## CITY OF PORTLAND

March 27, 2003

RE: 1263 Forest Ave., cor. Eleanor St. – 292-F-009 & 22 – R-5 zone (existing 2 family d.u.)

MORTGAGE INSPECTION OF: DEED BOOK 14808 PAGE 309 COUNTY Cumberland  
PLAN BOOK 184 PAGE 24 PARCEL 1 & 2

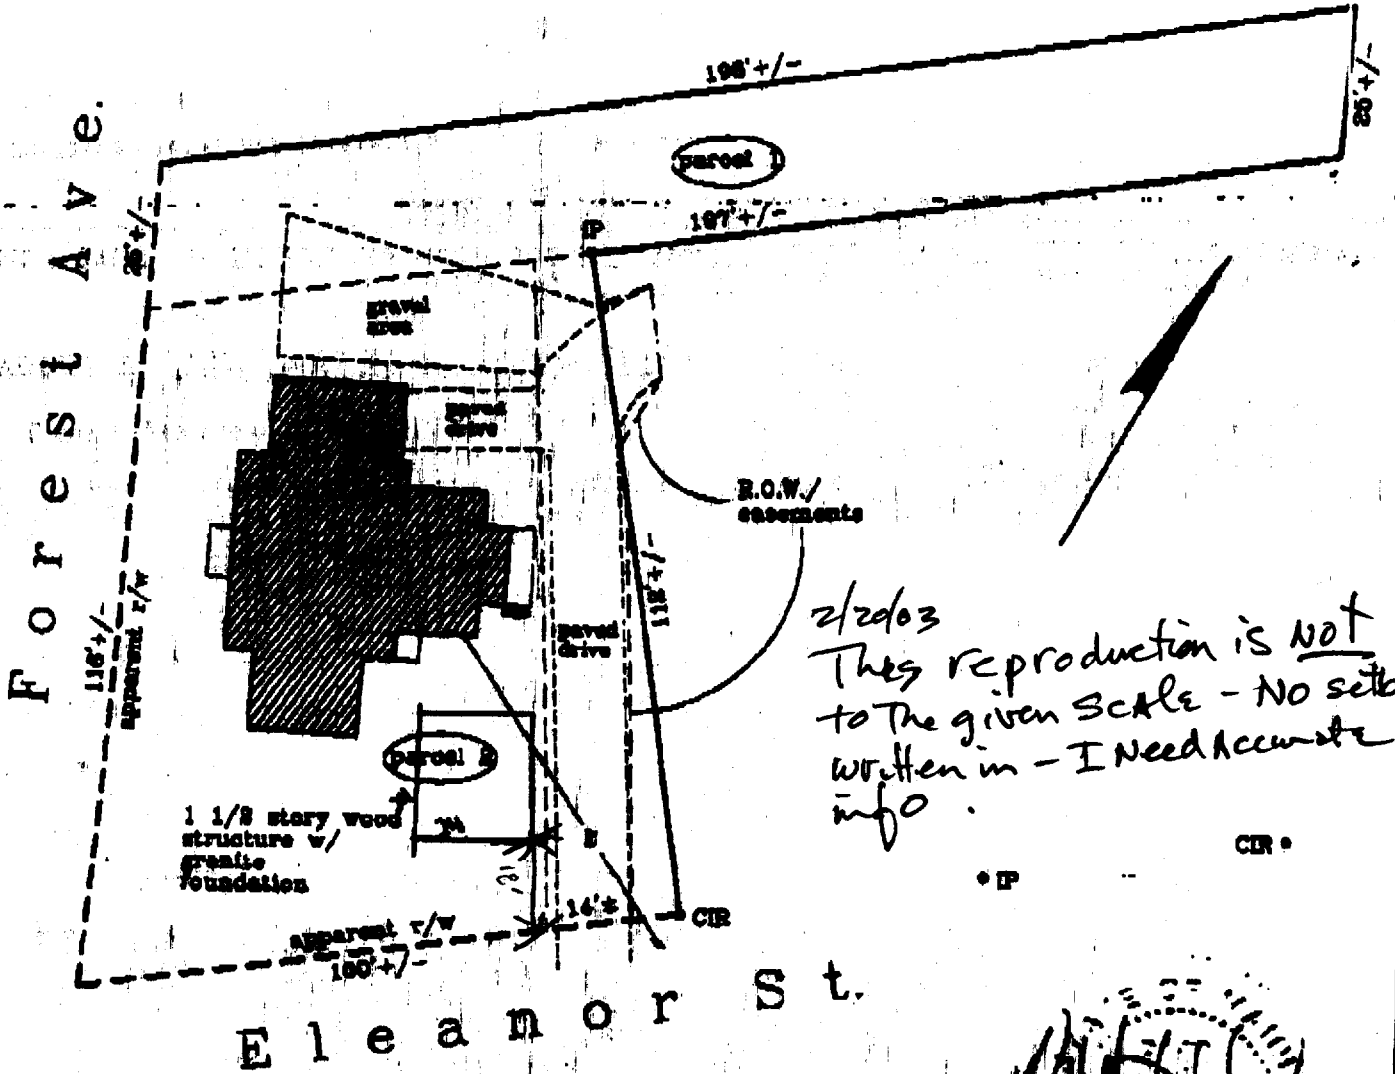
This site plan review must be resolved prior to the issuance of your request for a building permit to construct a new, detached two car garage. We have been having continued discussions concerning the requirements for an accurate plot plan for this proposed garage. I need an accurate site plan showing the setbacks. I will also need a cover letter from you explaining all the uses of the area above the garage. Your detached garage is also subject to the R-5 regulations (section 14-120) that limit the height of your garage to not more than 18 feet. Your original submittal shows that garage to be over 18 feet in height. I will need revised plans showing that you comply with the R-5 requirements. I have also included a copy of the dimensional requirements under the R-5 zone.
